A66 Trans-Pennine Project Scheme 0102 – M6 Junction 40 to Kemplay Bank

This is written response to Document 7.6 - Applicants Response to the Written Representations - on behalf of Penrith Properties Limited, BVI registered company 249033, (PPL) in respect of the proposed acquisition of land identified in Developer's Application Document 5.13 as Plot 0102-01-20 at Ghyll Mount, Gillian Way Penrith.

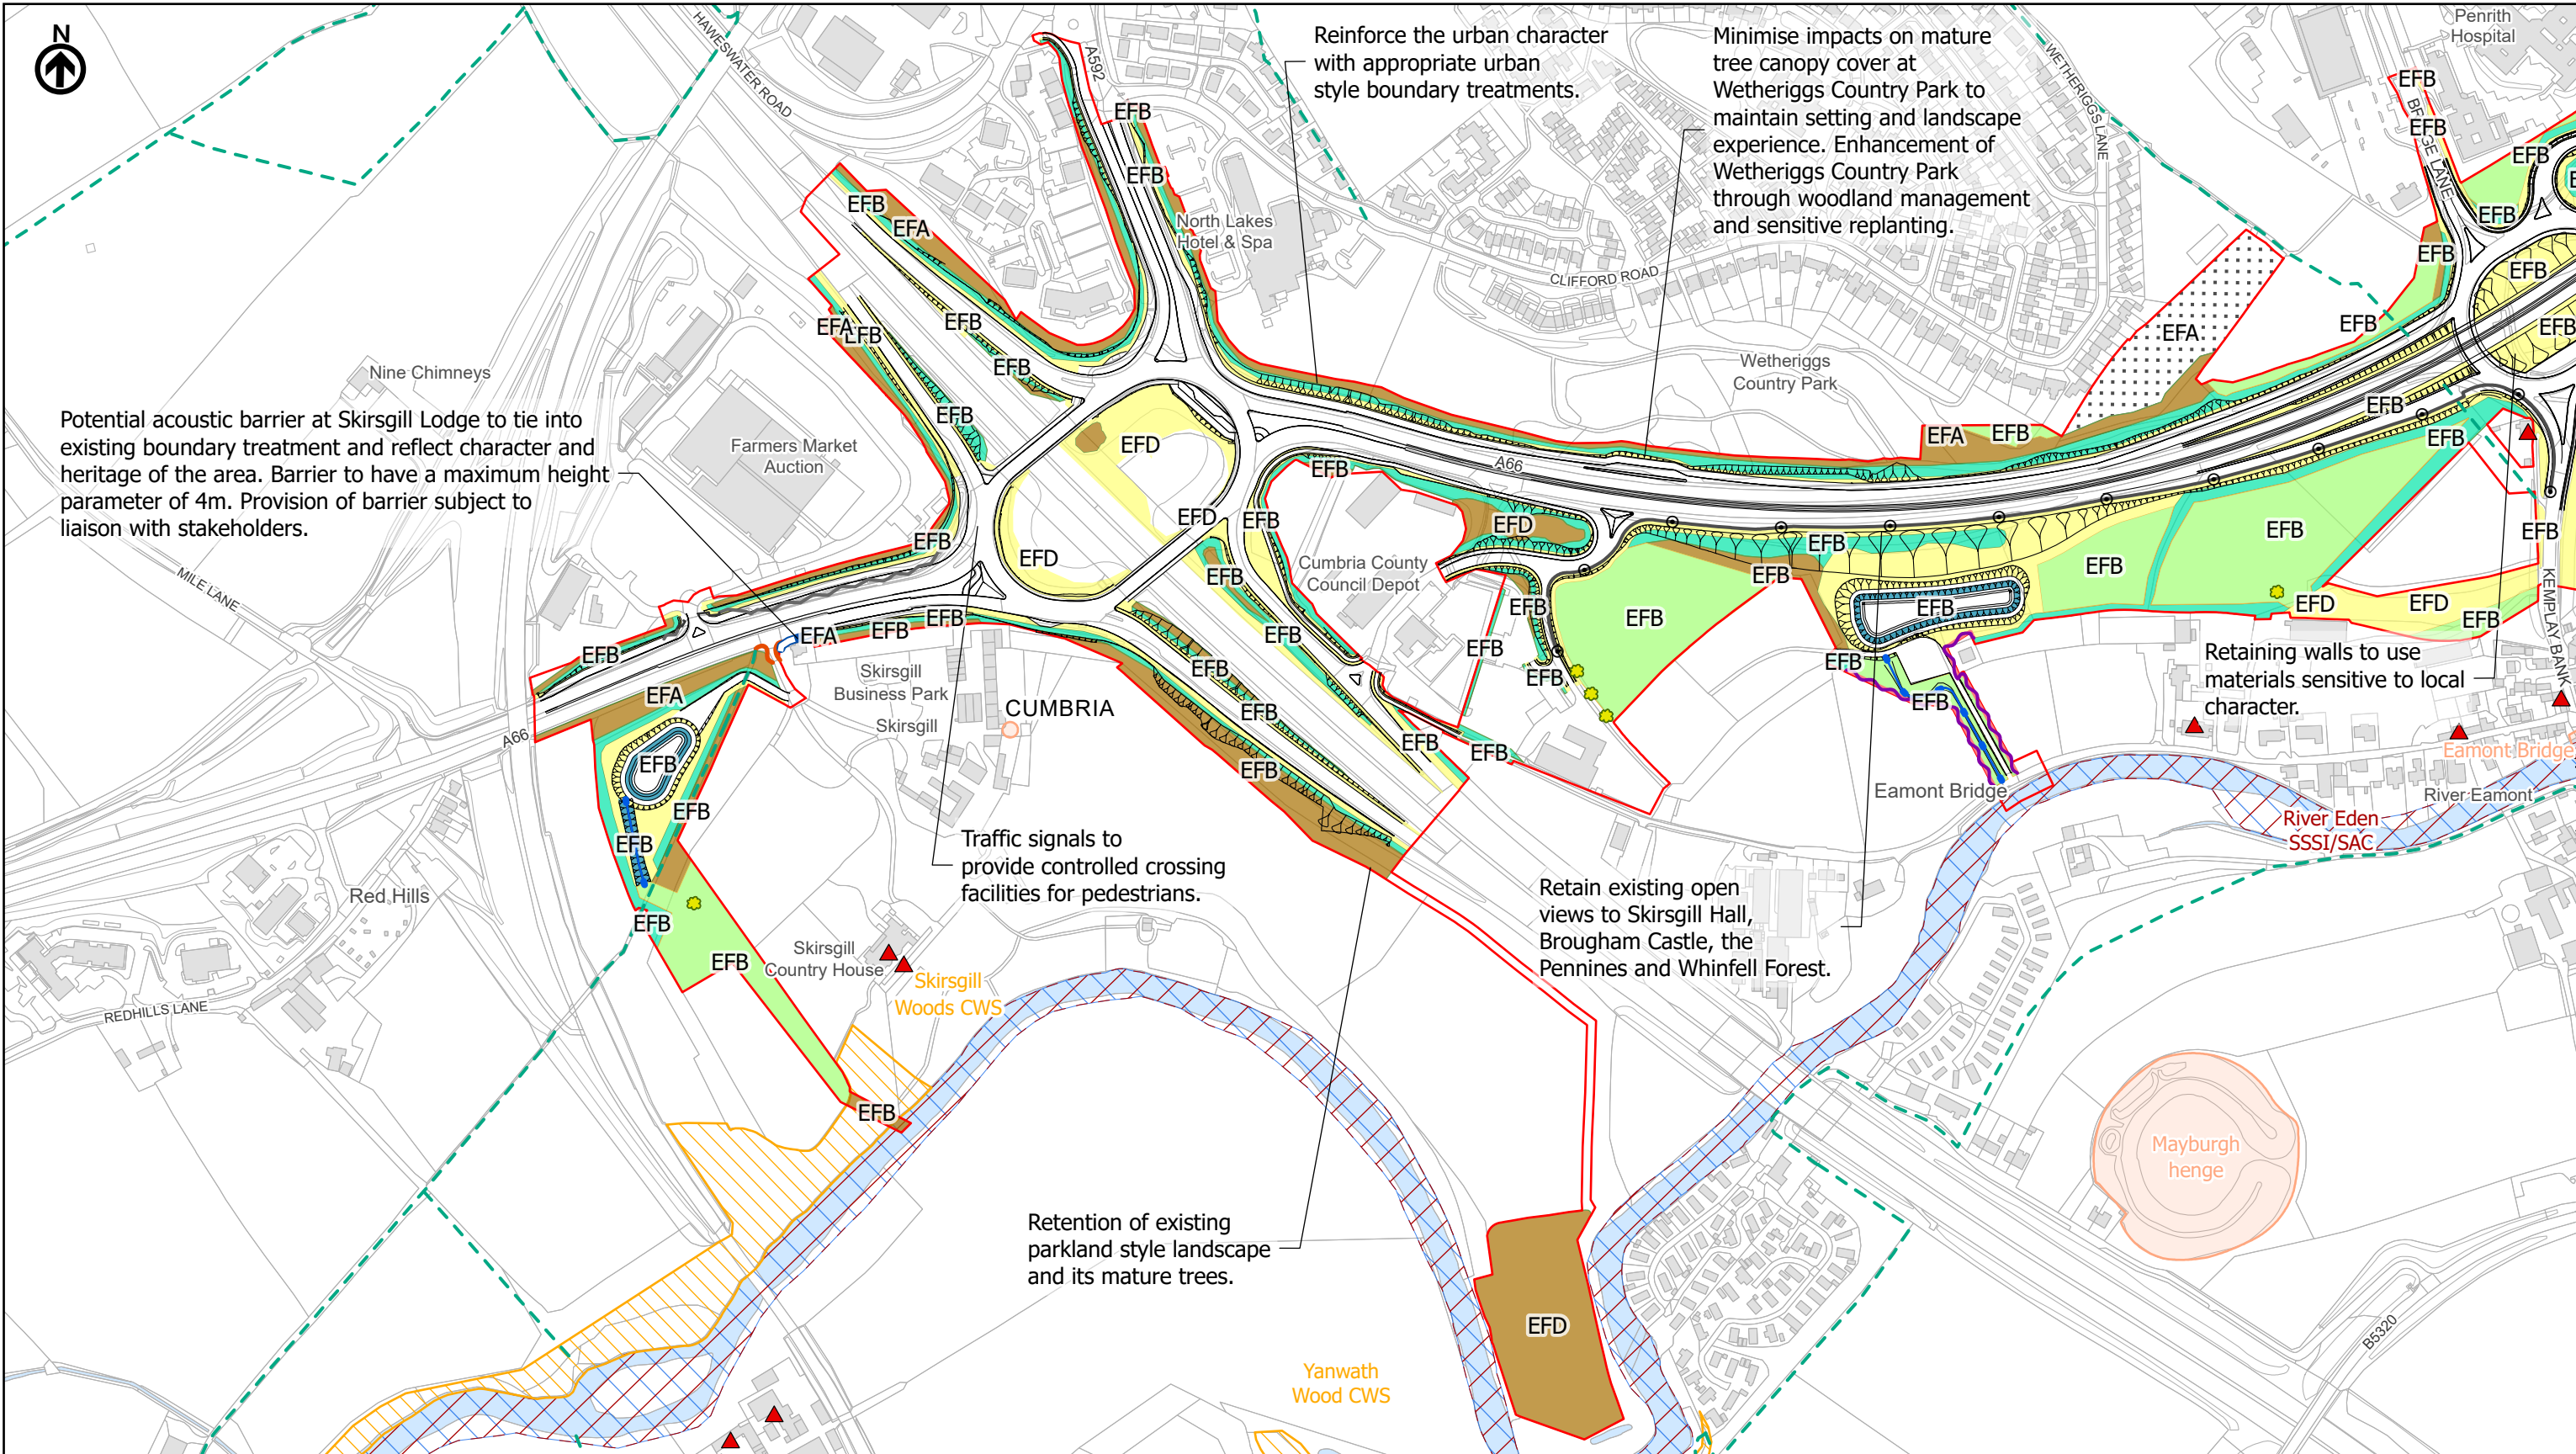
The Applicant refers to Figure 2.8.1, Sheet 1 of 2, (Document Reference 2.8) which identifies the Environmental Mitigation Scheme for Plot 0102-01-20. The purpose that the land is being required for mitigation is for EFA – Visual Screening and EFB – Landscape integration. Plot 0102-01-20 is therefore not identified for EFD – Nature conservation and biodiversity - implying that objectives of Document 2.7, Table 3.2, D-BD-05 are not the critical requirement for the acquisition of plot 0102-01-20. These Visual Screening and Landscape integration functions are already served by the existing woodland and scrub planting .

objectives of the EMP through the Environmental Mitigation Strategy. The acquisition of Plot 0102-01-20 is unnecessary given that the proposed visual screening and landscape integration sought of the plot and are negative for biodiversity given the proposal to remove maturing trees and scrub and replacing it with similar. There is no commitment from the Applicant in relation to the replacement ratios or quality of planting in the Register of Environmental Actions and Commitments.
